Your Ref: OWPC6982
Our Ref: P/86/15/PL 11-08-2015
Please ask for:
Mr S Davis

1 No. 2 bedroom semi-detached bungalow
11 Abbotsbury Pagham

Thank you for your internet representation made on 18th September 2015 which has been recorded as '**an objection**' with the comments as follows:

Proposed Floor Plan & Site Plan

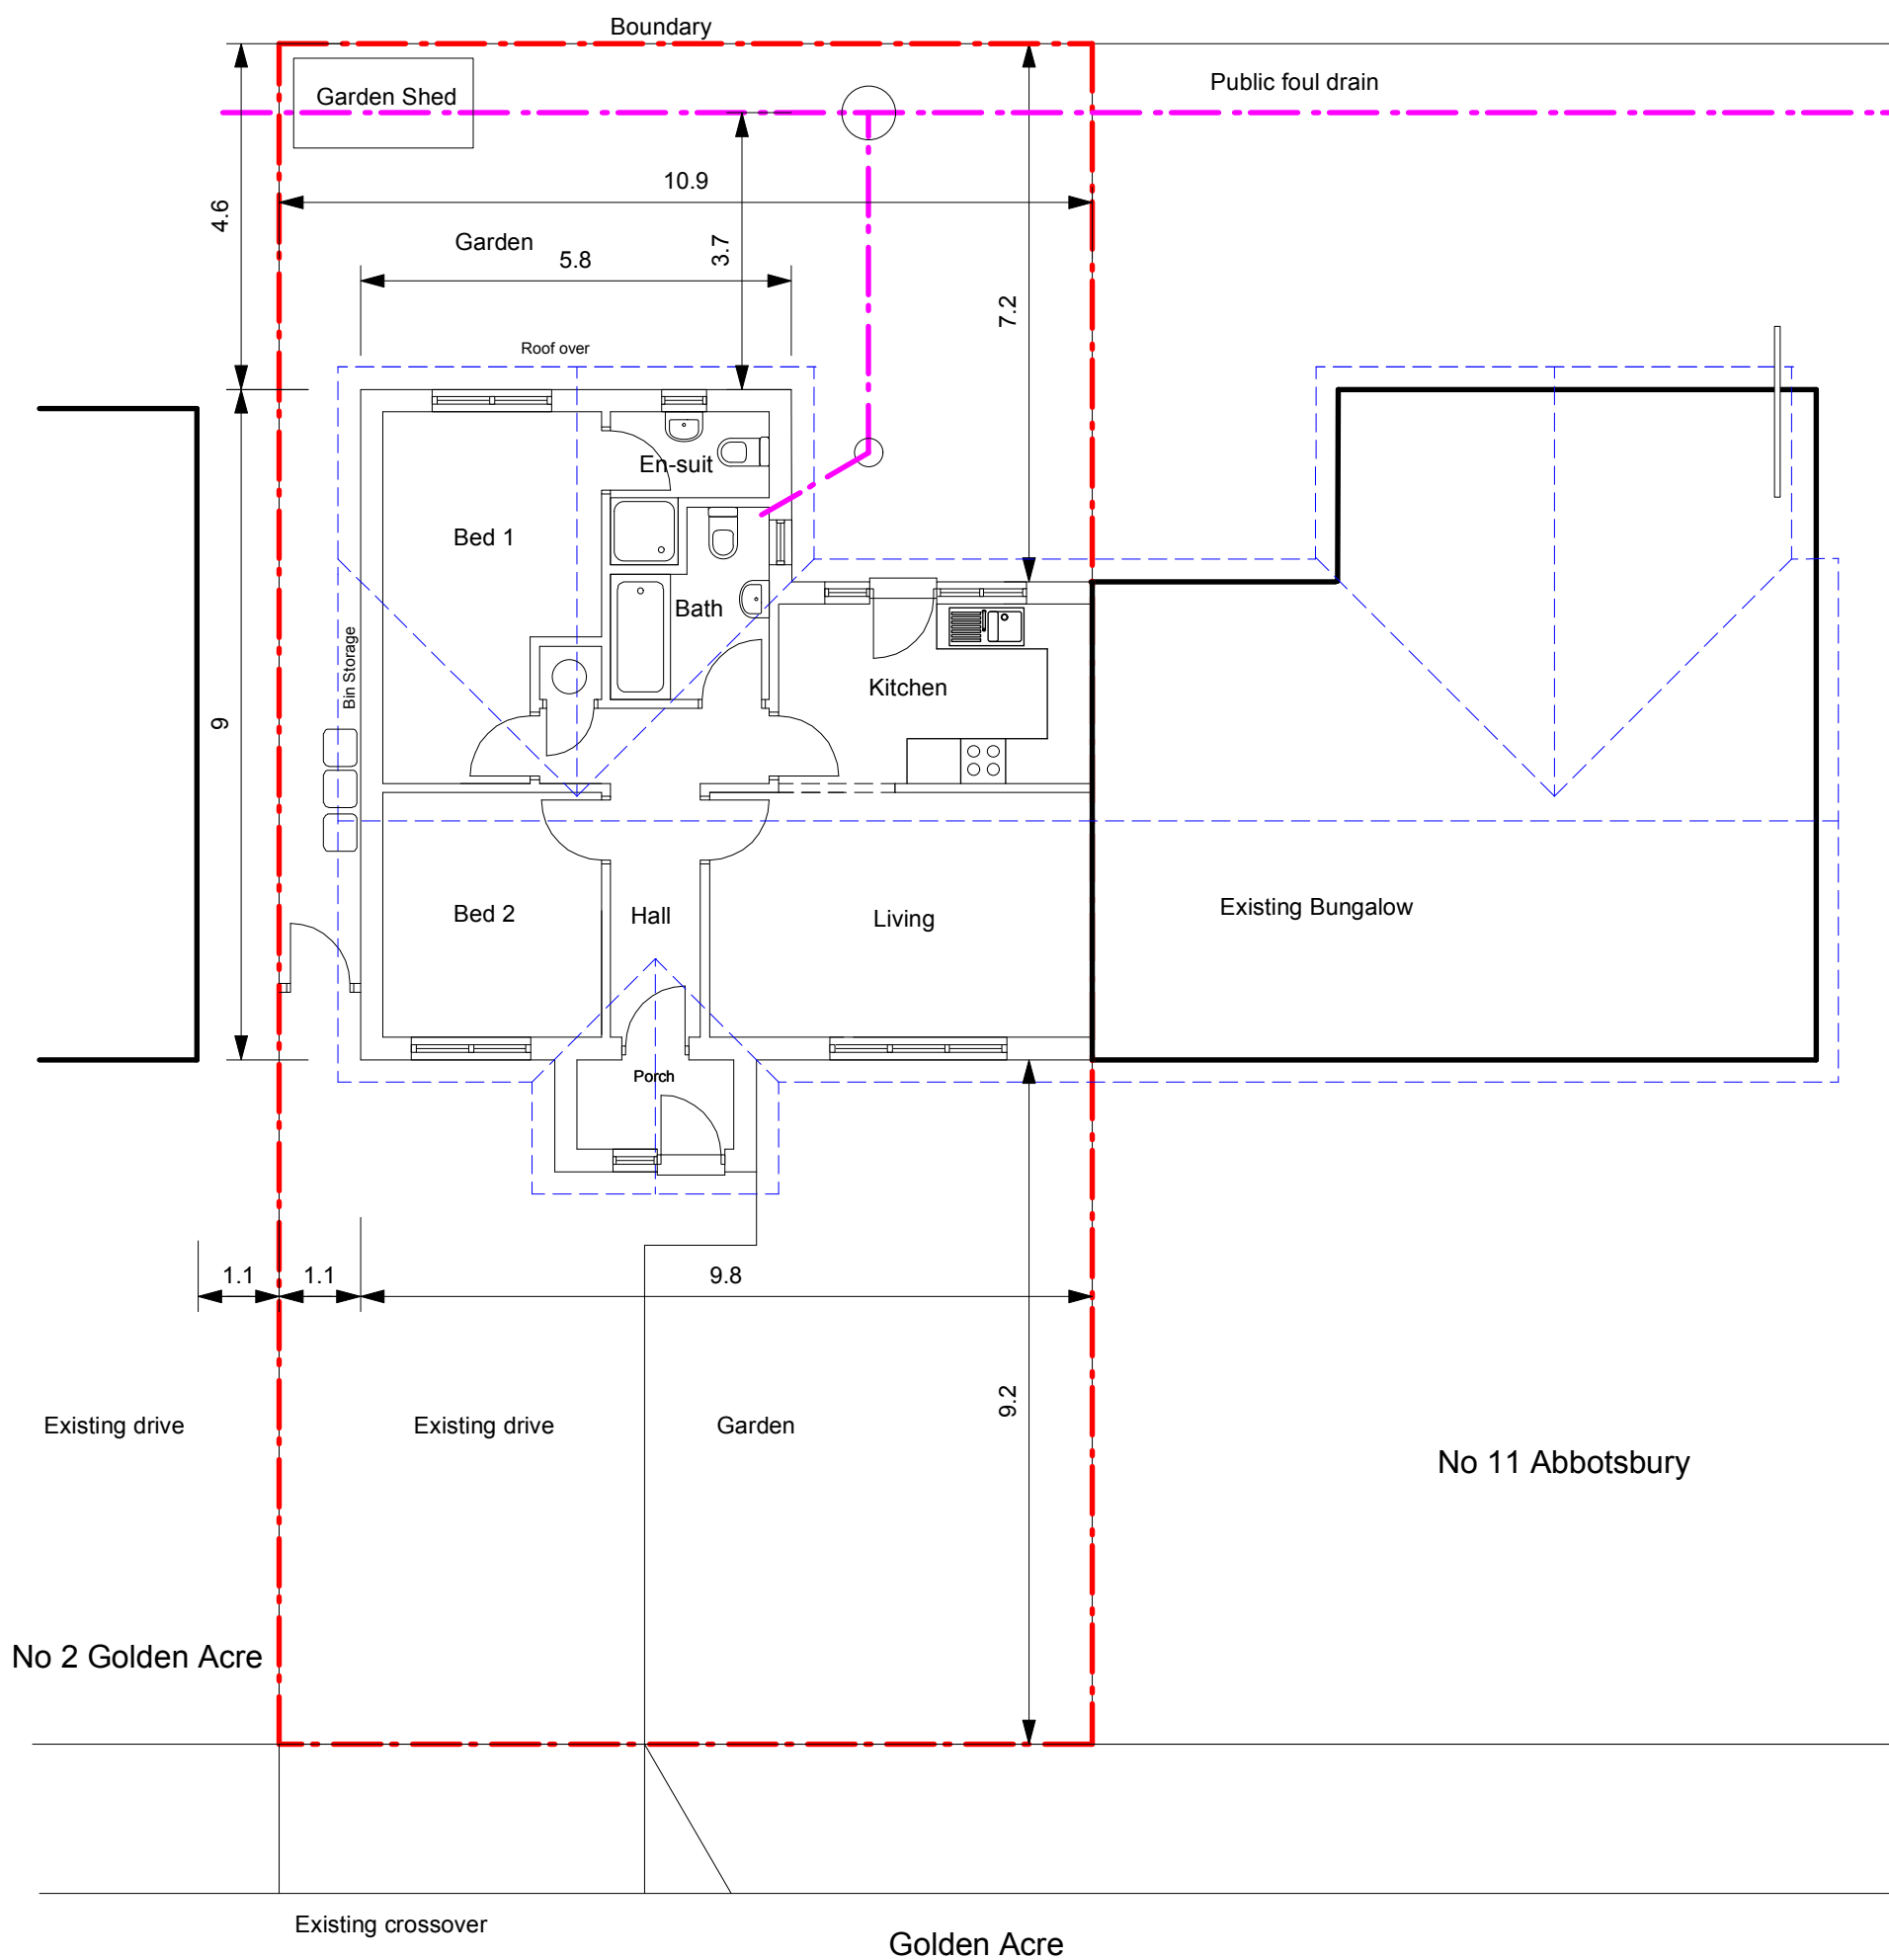
In regard to the proposed driveway which would run alongside our own, we are concerned of the consequences on our privacy as we have primary living quarters at the front of our home.

The plans state no crossover required, whereas this would actually be a requirement in Abbotsbury.

The plans state no trees or hedges on the development site; there is a large, mature Palm Tree together with a Pear Tree.

Proposed Rear Elevation

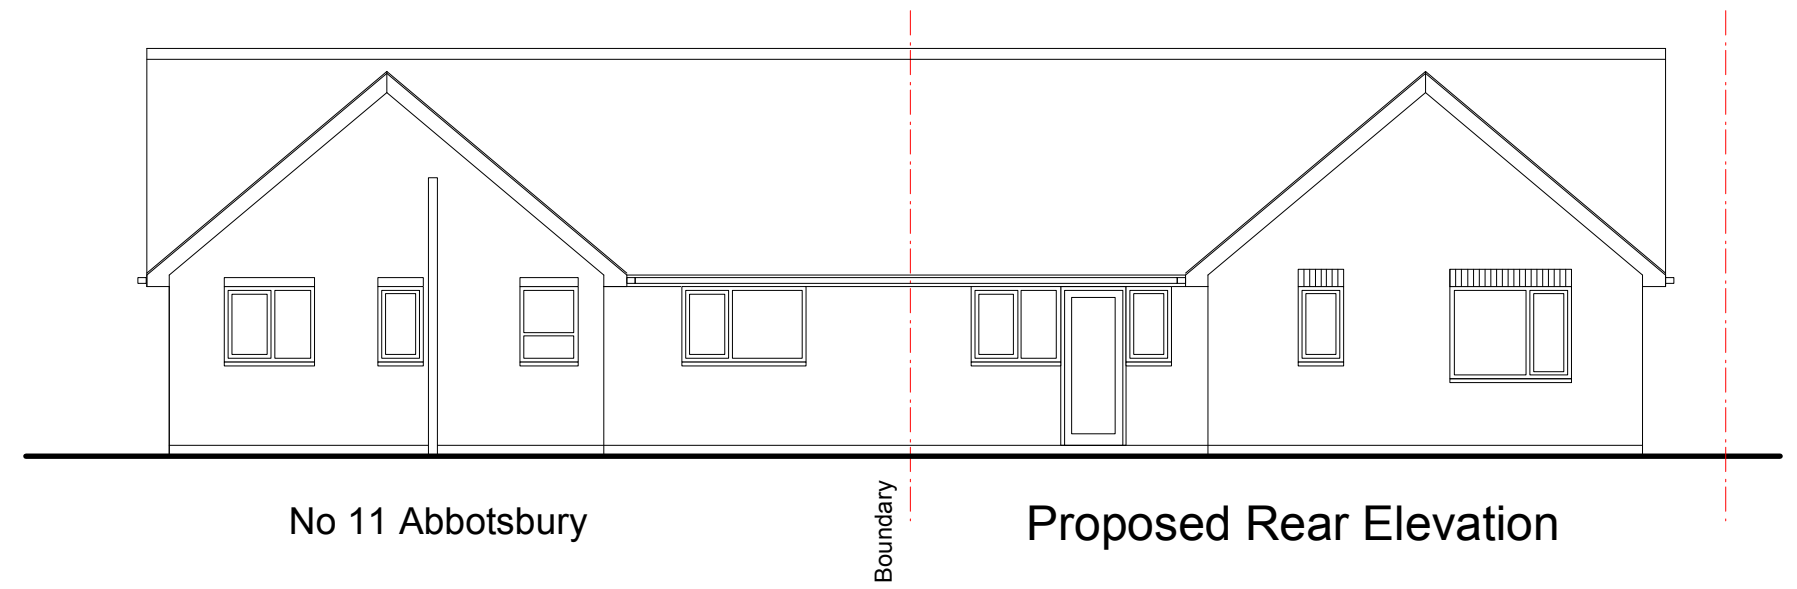
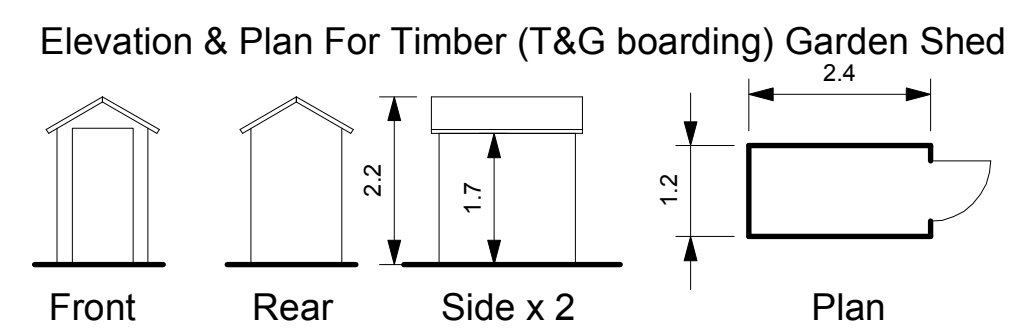
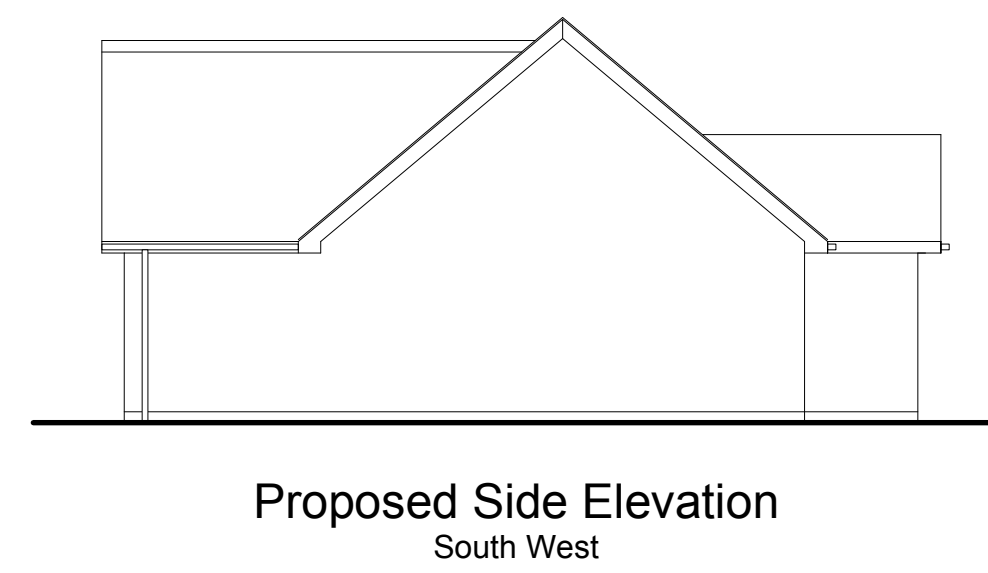
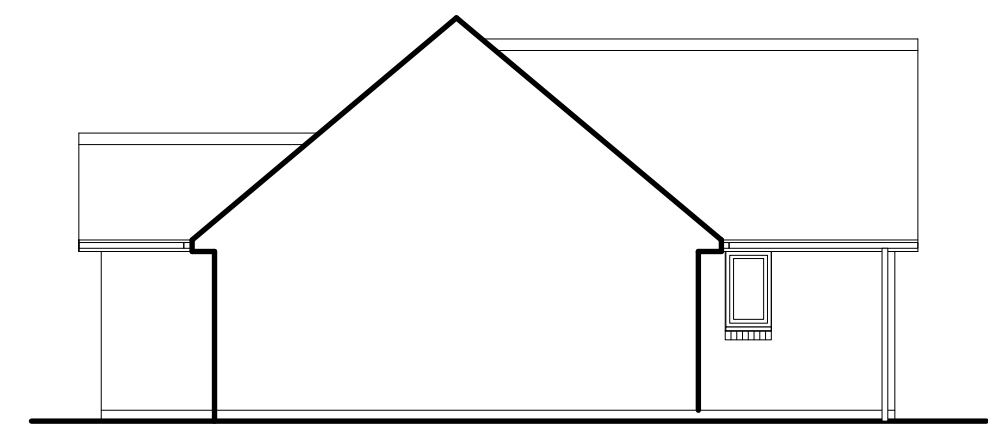
Due to the proposed dwelling being built in the rear garden of the current property, it will block a considerable amount of daylight from primary living quarters at the rear of the bungalow, our mature back garden, and our bathroom. Our Right of Light is protected under the Prescription Act 1832, having received over the minimum 20 years enjoyment of unobstructed daylight.

The proposed construction would have a negative impact on the visual enjoyment of our home. Due to the size and height it would be visually intrusive and overbearing on our property when viewed from our garden and primary living quarters, thereby being detrimental to our enjoyment of our home, garden, the light, views and space around us.

The proposed new dwelling would be less than 5 metres from our property. We believe that potentially having another family in such close proximity to our home will be detrimental to our standard of living. We made our home here as this is a quiet area, if the proposal were to go ahead we are concerned that we would then have four homes/families adjacent to our property. This would have a negative impact on the enjoyment of our home due to the noise and loss of privacy.
